From: Cornelis Duba <Cornelis.Duba@endeavourenergy.com.au>
Sent: Friday, 30 April 2021 4:30 PM
To: Christopher Fraser
Cc: DPE CSE Information Planning Mailbox; Jeff Smith
Subject: NSW Planning, Industry & Environment Response to Submissions S29/3/97-Mod-1 Modification to 50 Peter Brock Drive, Eastern Creek – Event Parking Area

I refer to the Department's letter of 16 April 2021 advising of the Response to Submissions for State Significant Development DA S29-3-97-Mod-at 50 Peter Brock Drive, Eastern Creek (Lot 4 DP 1079897) for 'Modification of the Event Parking Area involves: regularising earthworks for an existing on grade event carparking area; sealing of the event car park, retaining wall and minor filling in the north-east corner of the event carpark; landscaping of earth batters; regularising stormwater works associated with the event carpark; additional stormwater works including installation of pipes, drainage pits and the addition and retention of drainage swales'. Submissions need to be made to the Department by 30 April 2021.

2.4. Endeavour Energy (Email Submissions)

PLAN REFERENCE:
6334-CATENARY 1

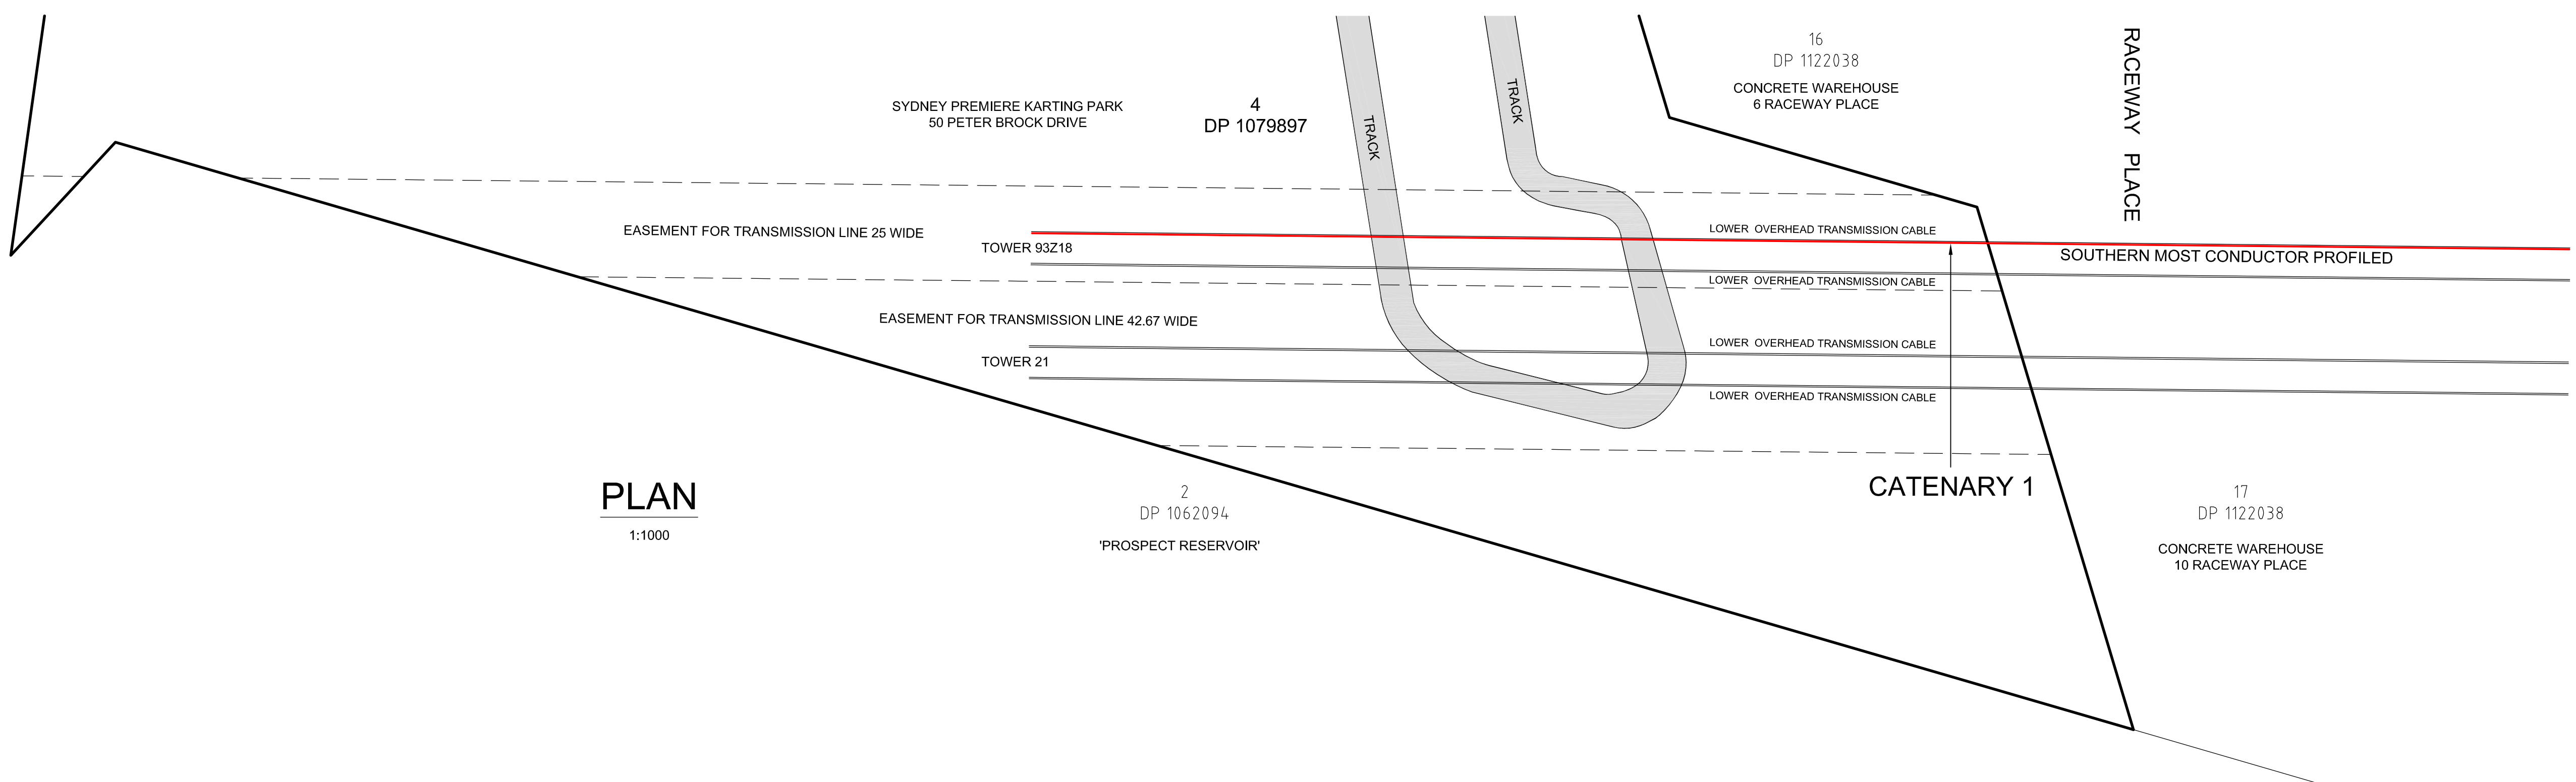
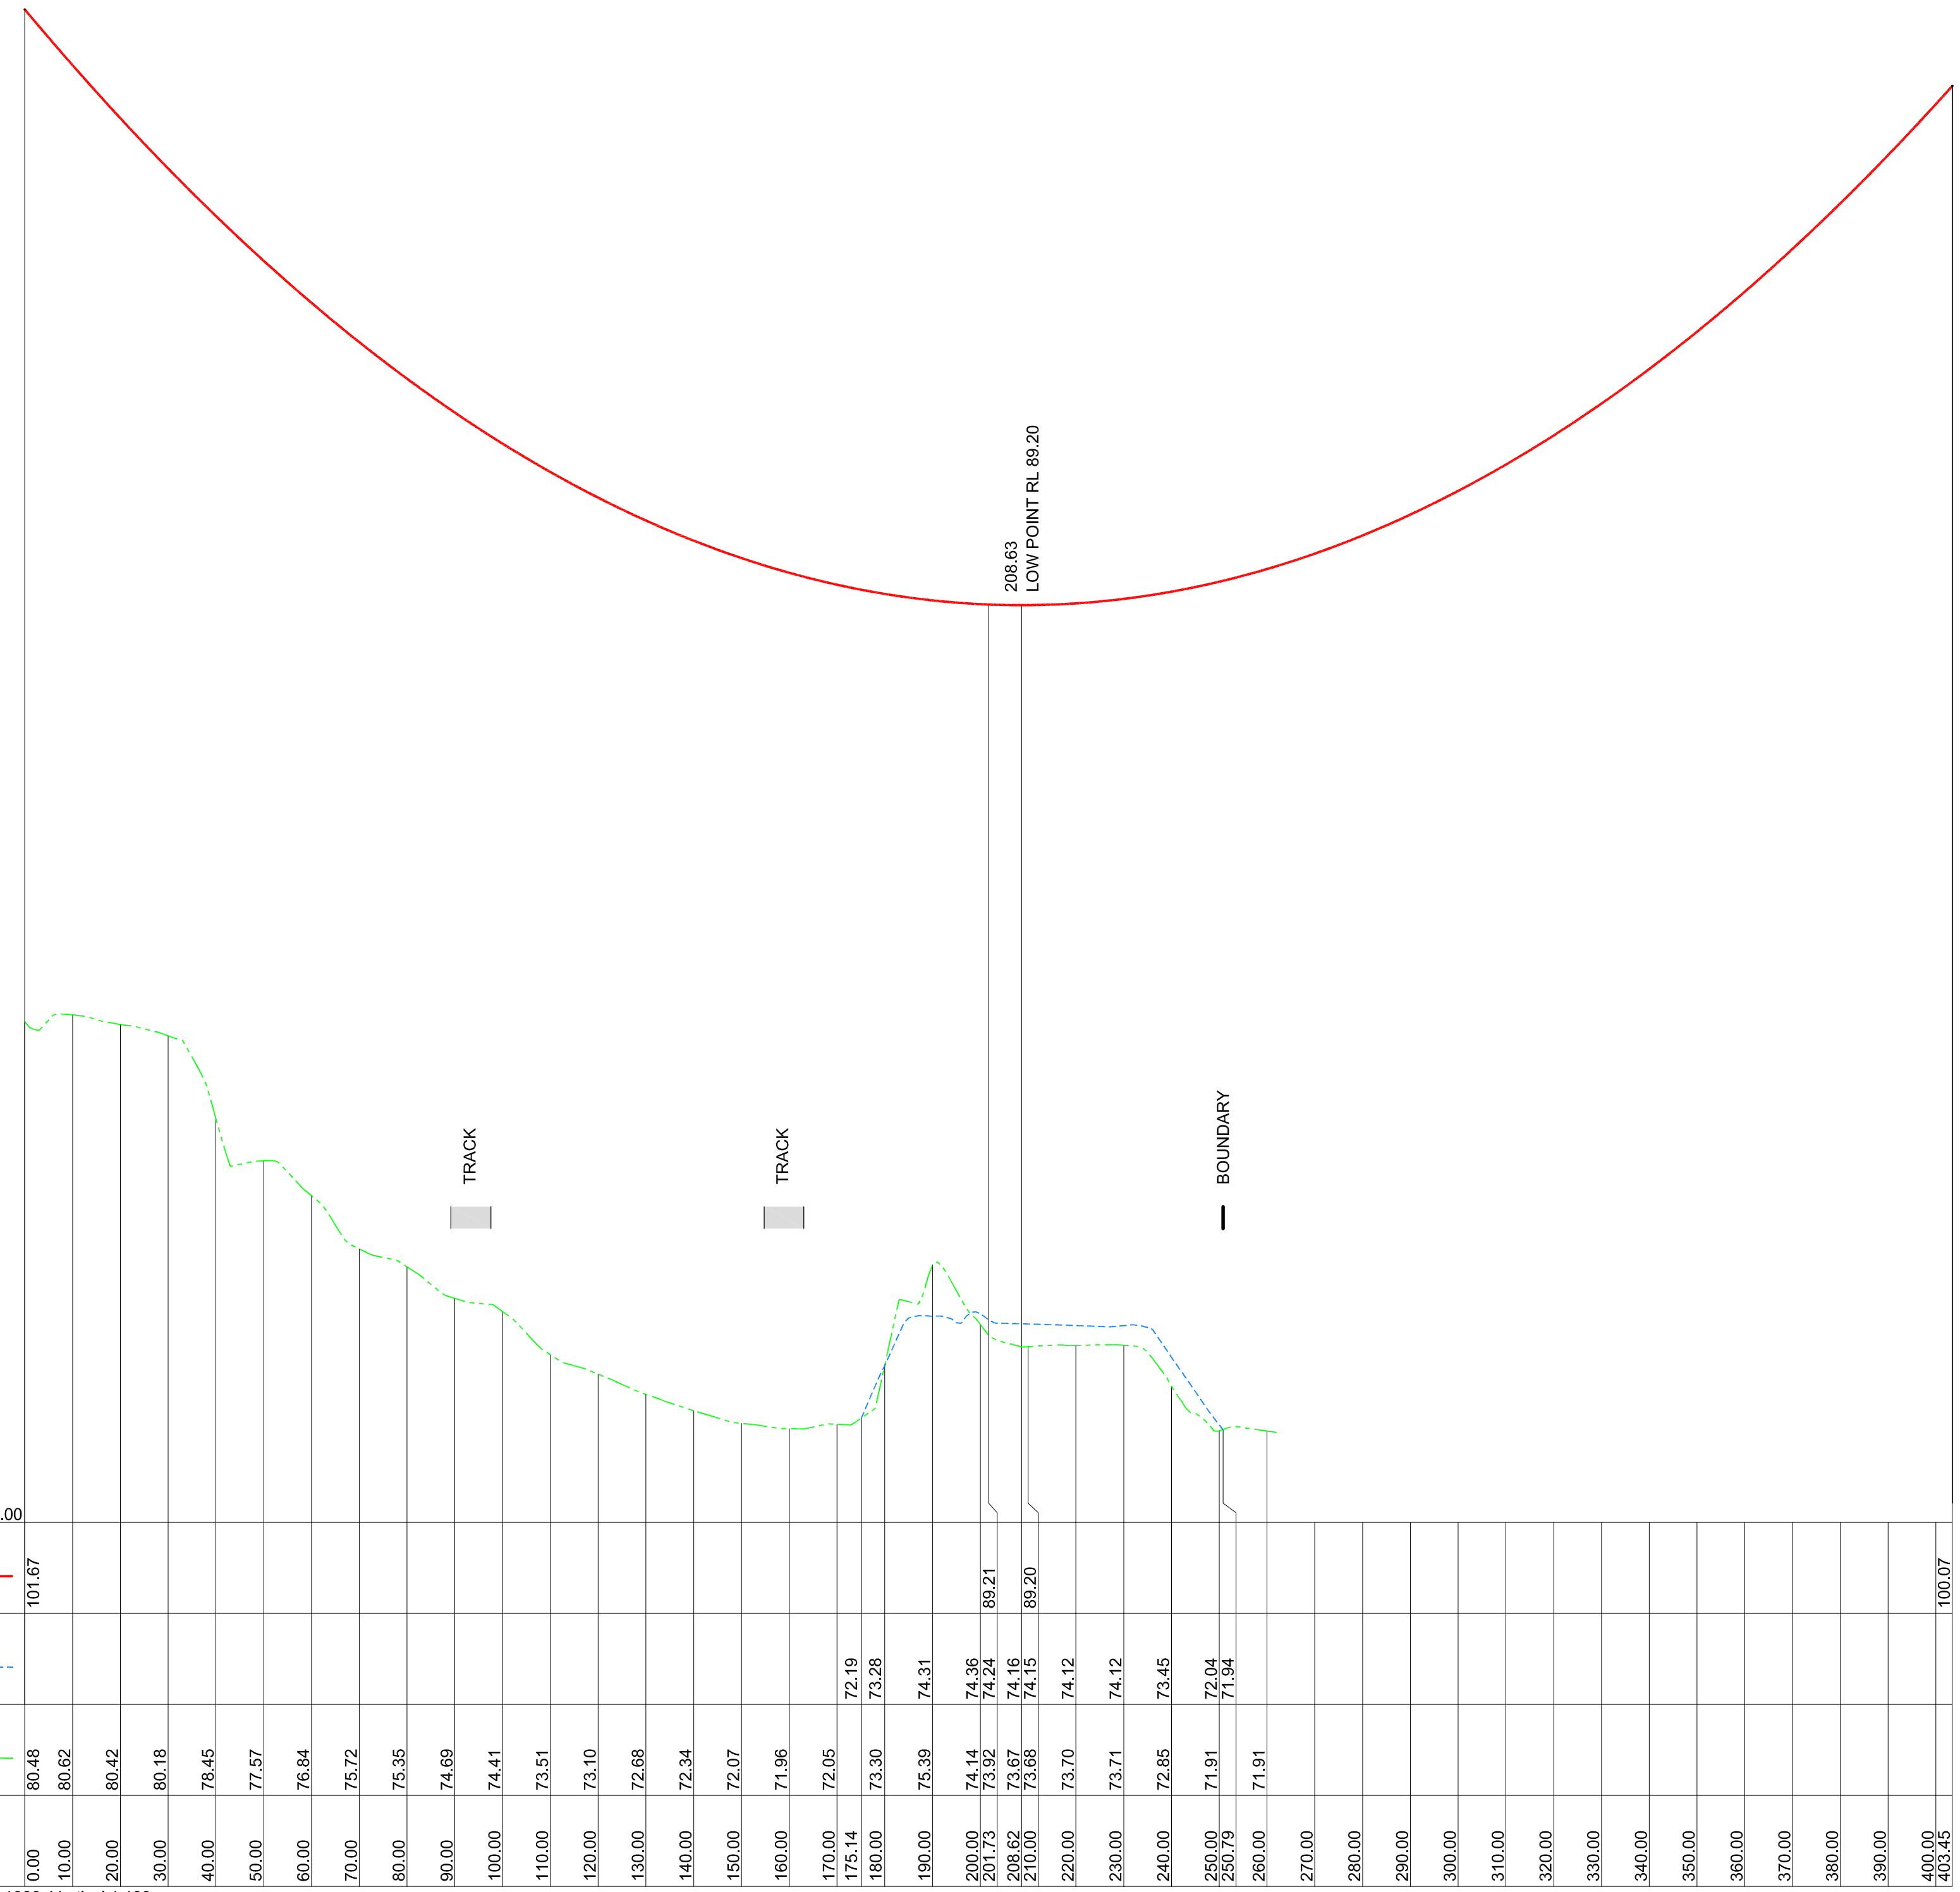
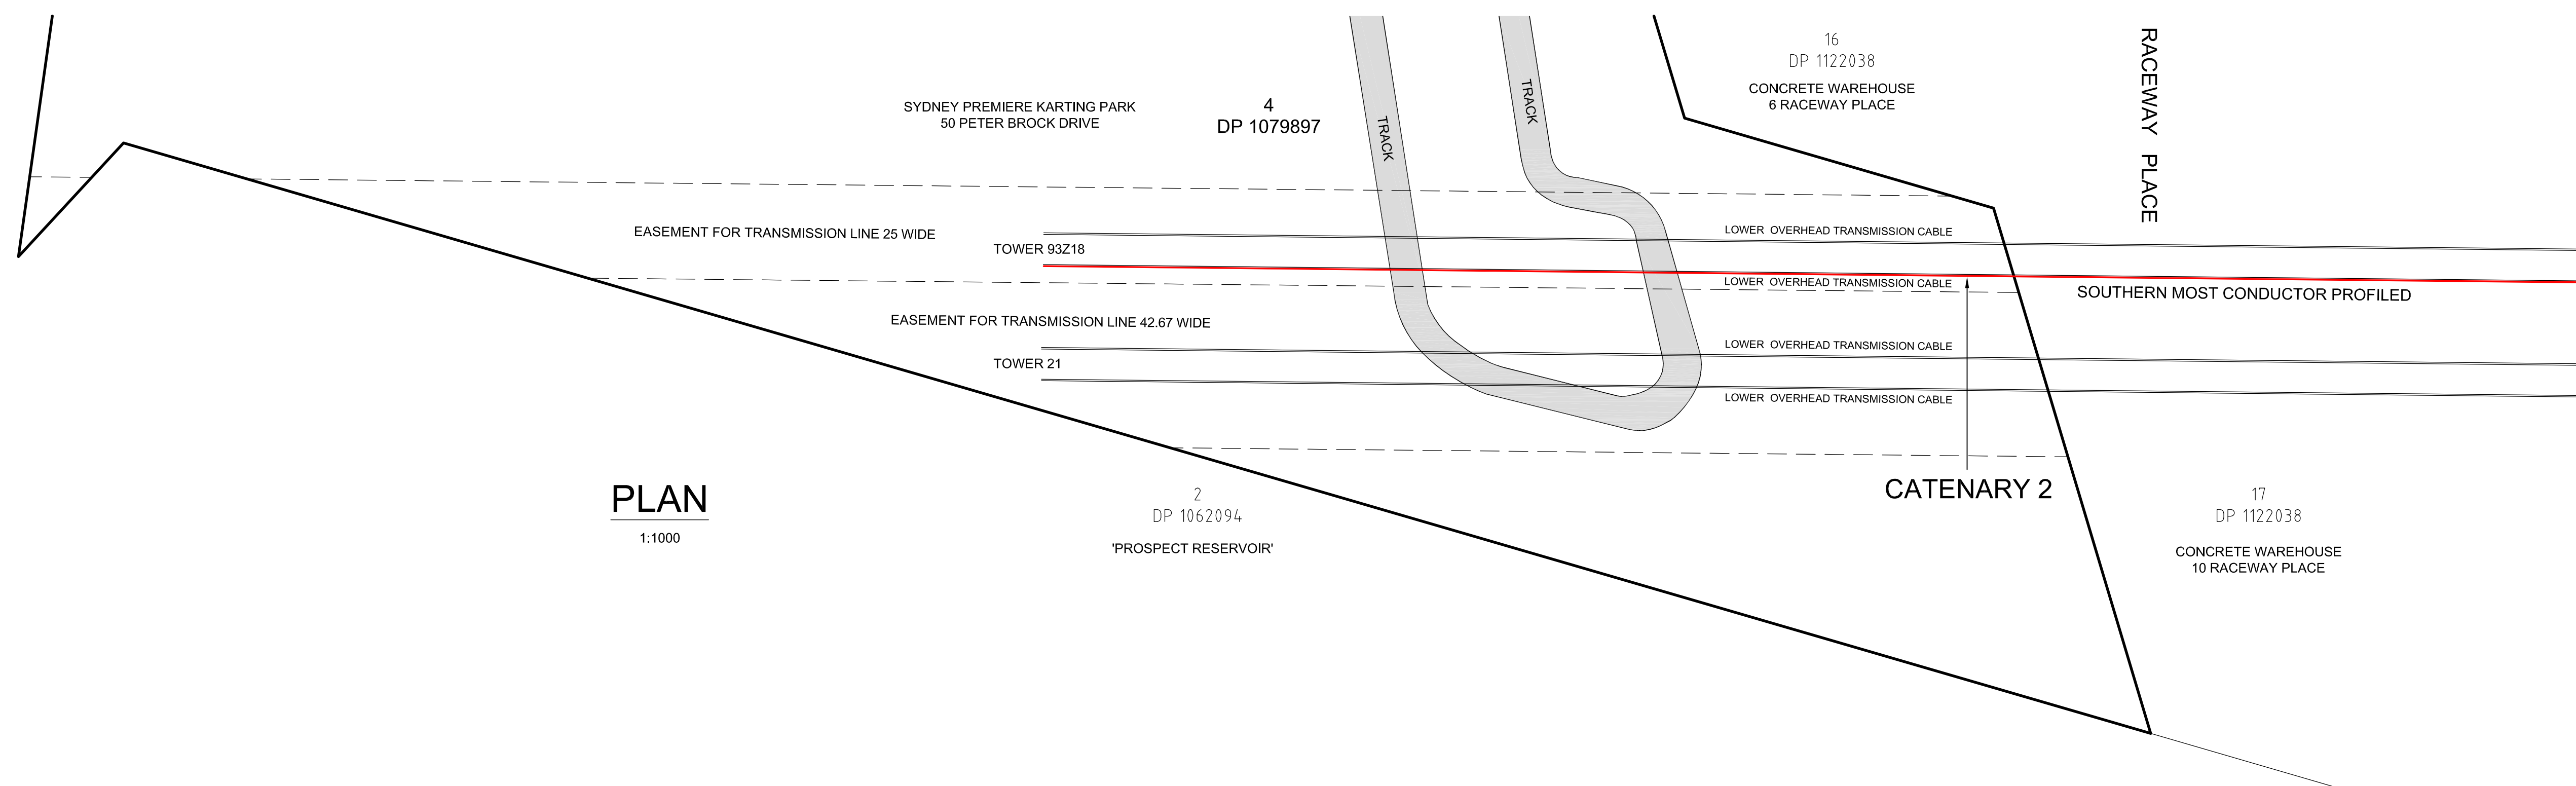
- a) The most recent survey showing centreline profile of the transmission lines over the Event Carpark area (Usher & Company Plan ref 6334-Catenary 1, 2, 3, 4, 11.03.2021) appears generally acceptable but is to have the proposed minor carpark regrading works ground profile superimposed over the surveyed profile and forwarded for EE sign off.
